Sent: 10 November 2025 08:25
To: DC Admin; Louise Bearcroft; Martin Stephenson
Subject: Revised Comments on Application 2025/44/92737/E

Discharge of details reserved by conditions 10 (Phase II Intrusive Site Investigation Report), 11 (Remediation Strategy), 14(a) (coal mining activity), 16, 17, 18, 19, 20 (drainage), 21 (CEMP), 23 (estate roads), 24 (acoustic barrier) on previous permission 2023/92079 for outline application for erection of residential development of 10 dwellings, demolition of existing extension at 27 Moor Lane, widening of existing access and realignment of boundary walls.

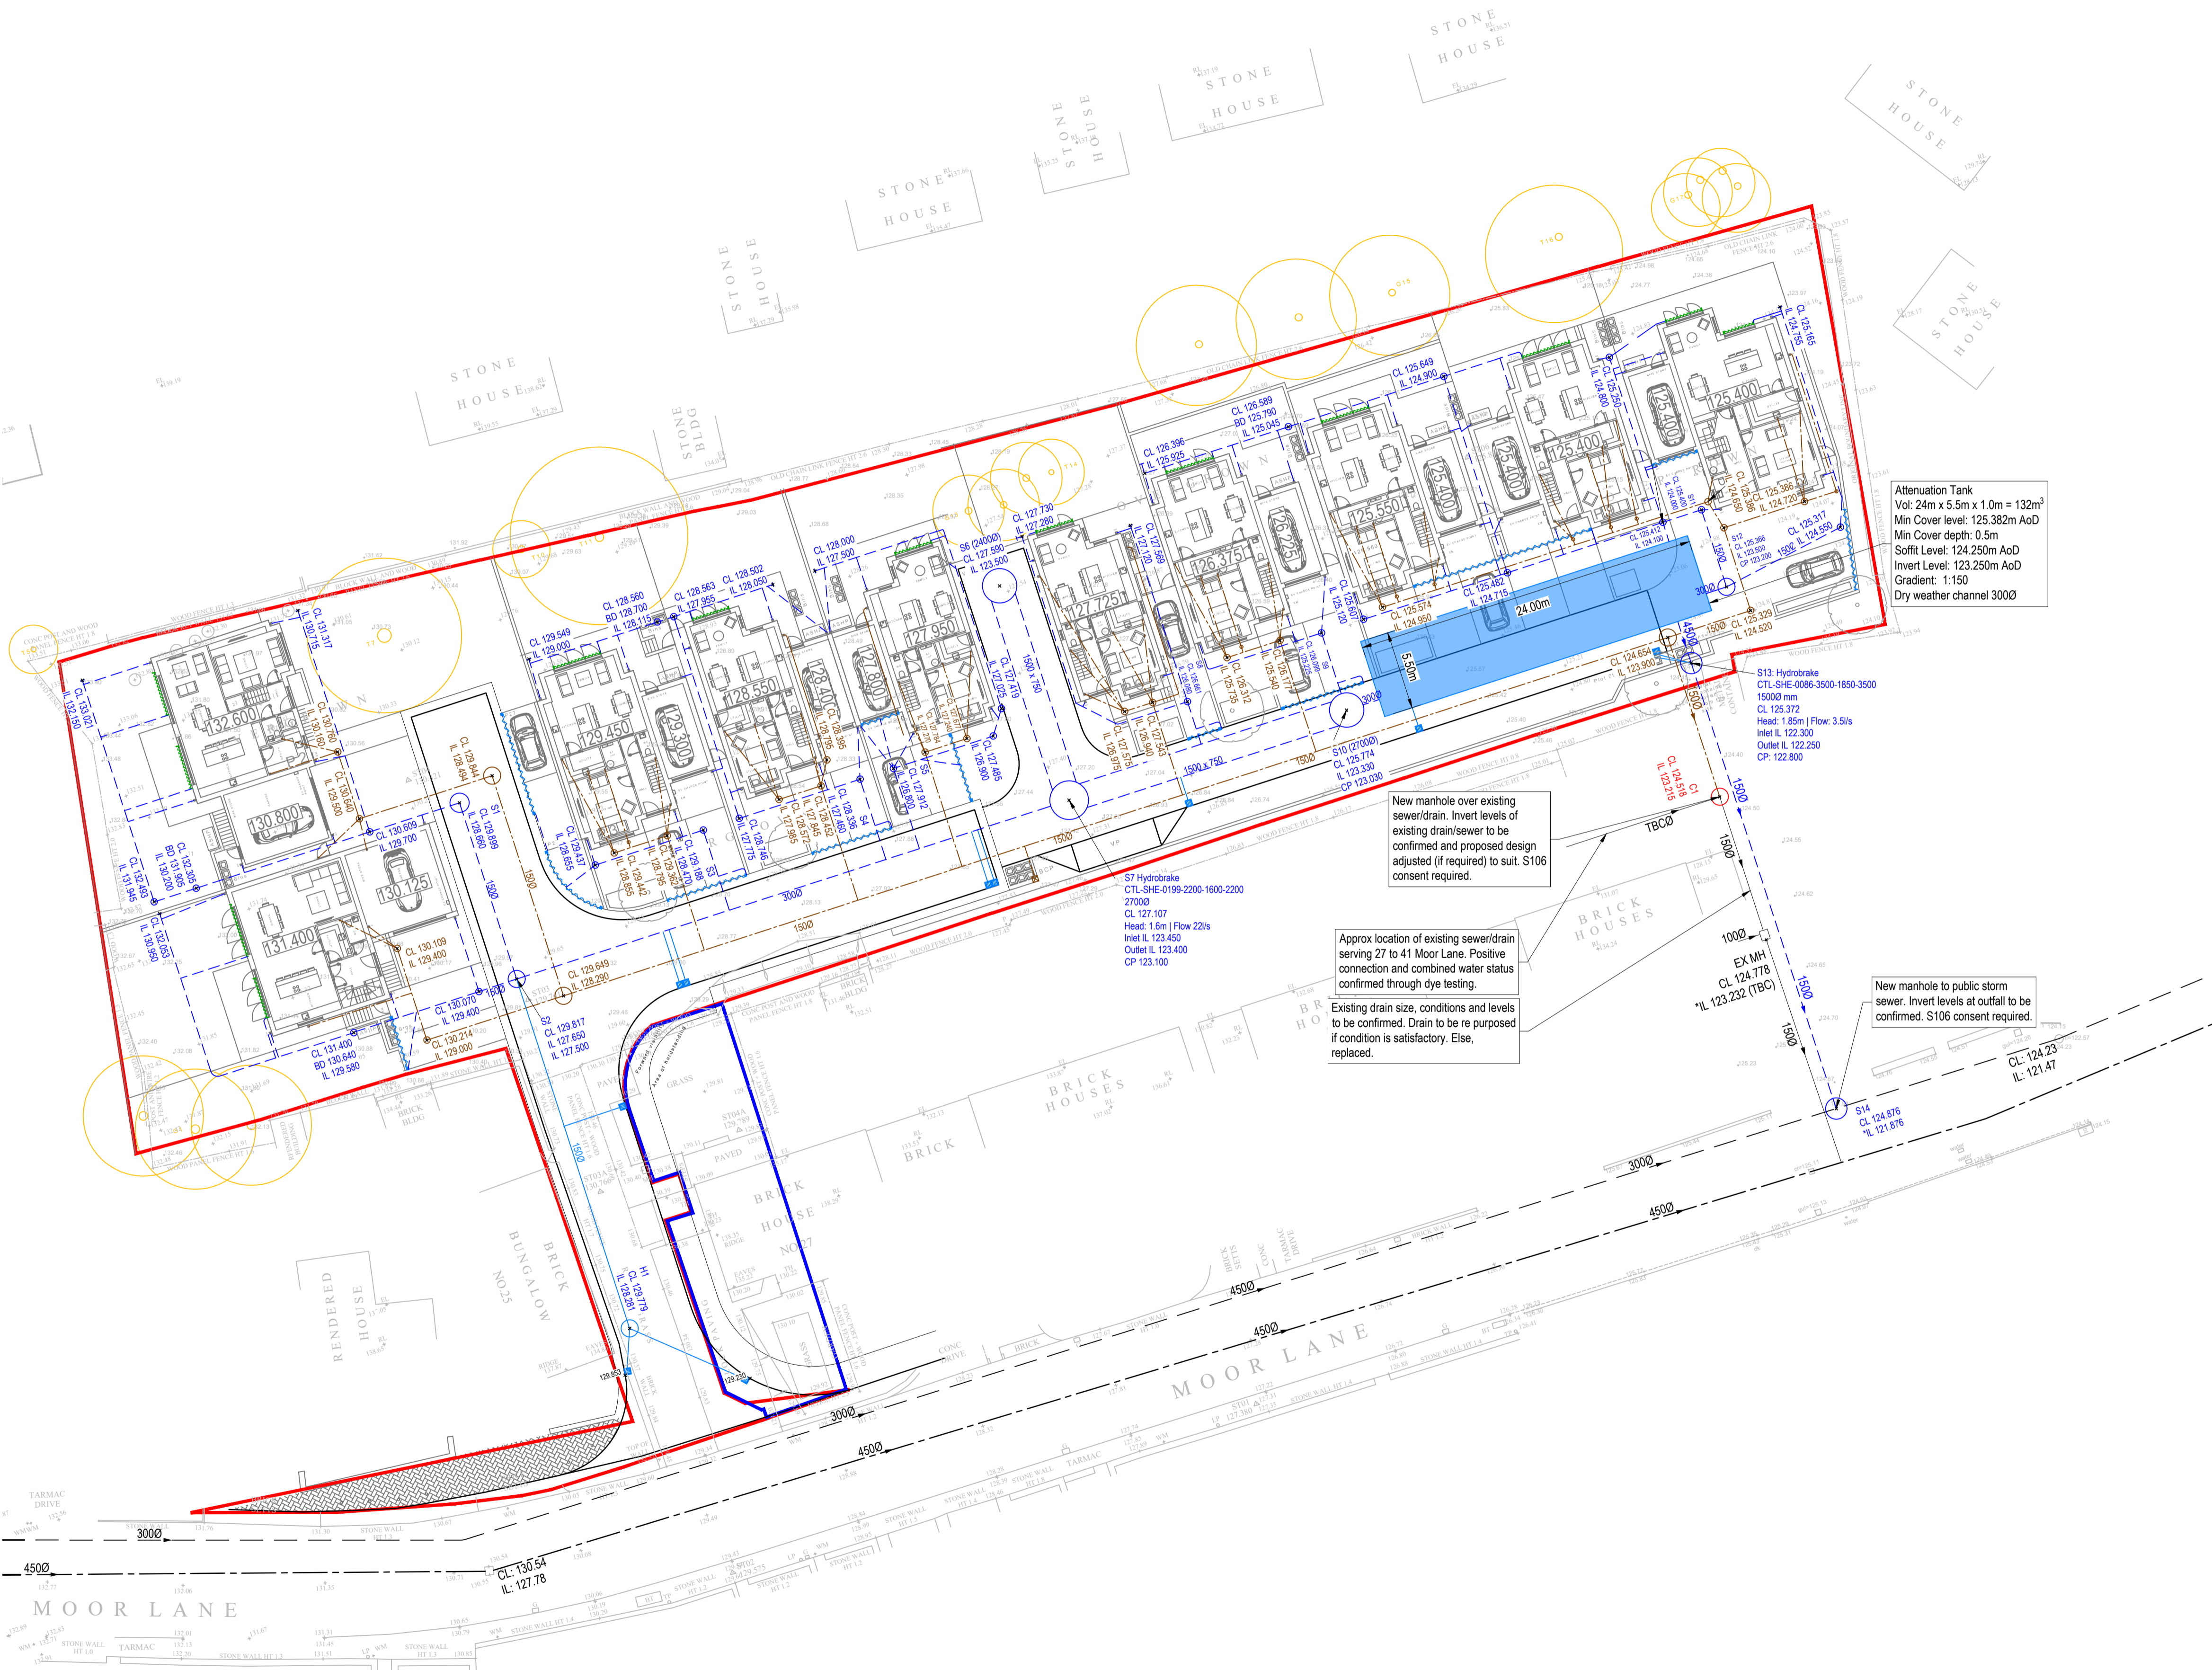
I consider that the proposed scheme of combining the foul and surface drainage on site should not be accepted. A combined system means that a flood event breaching the capacity of the site attenuation (or a simple blockage/ failure of the drainage connection leading out onto Moor Lane) would result in the discharge of water containing foul sewage across neighbouring properties downgradient of the site. As the attenuation tank and drainage connection is located at/close to the subject site's downgradient boundary, then it is off-site properties rather than the subject site's properties that face increased risk. There is a common law duty that the developer must not increase the flood risk of neighbouring properties therefore the proposed scheme is not acceptable.

The proposed scheme of a combined system also presents a single point of failure risk regarding directing the site's drainage through one 150mm drainage pipe off site. In addition, combining the surface water and foul drainage presents additional risks in relation to the inspection and maintenance of the attenuation tanks due to increased potential of exposure of maintenance staff to contaminants (pathogens, etc.) associated with foul drainage.

This condition relates to the means of disposal of foul water from the site. The proposed scheme specifies routing both the surface water and foul drainage on-site together and directing them to the Combined Sewer on Moor Lane. Yorkshire Water has indicated in their consultation response (Ref A/02700 dated 31/10/2025) their objection to the proposed surface drainage scheme for the site indicating that surface water from the site must be routed to the separate surface water sewer on Moor Lane. By definition this means that all foul and surface water drainage from the site must be kept separate throughout the site (i.e. there must be no combined drainage on site). Therefore, the proposed scheme cannot be implemented and therefore this Condition cannot be discharged.
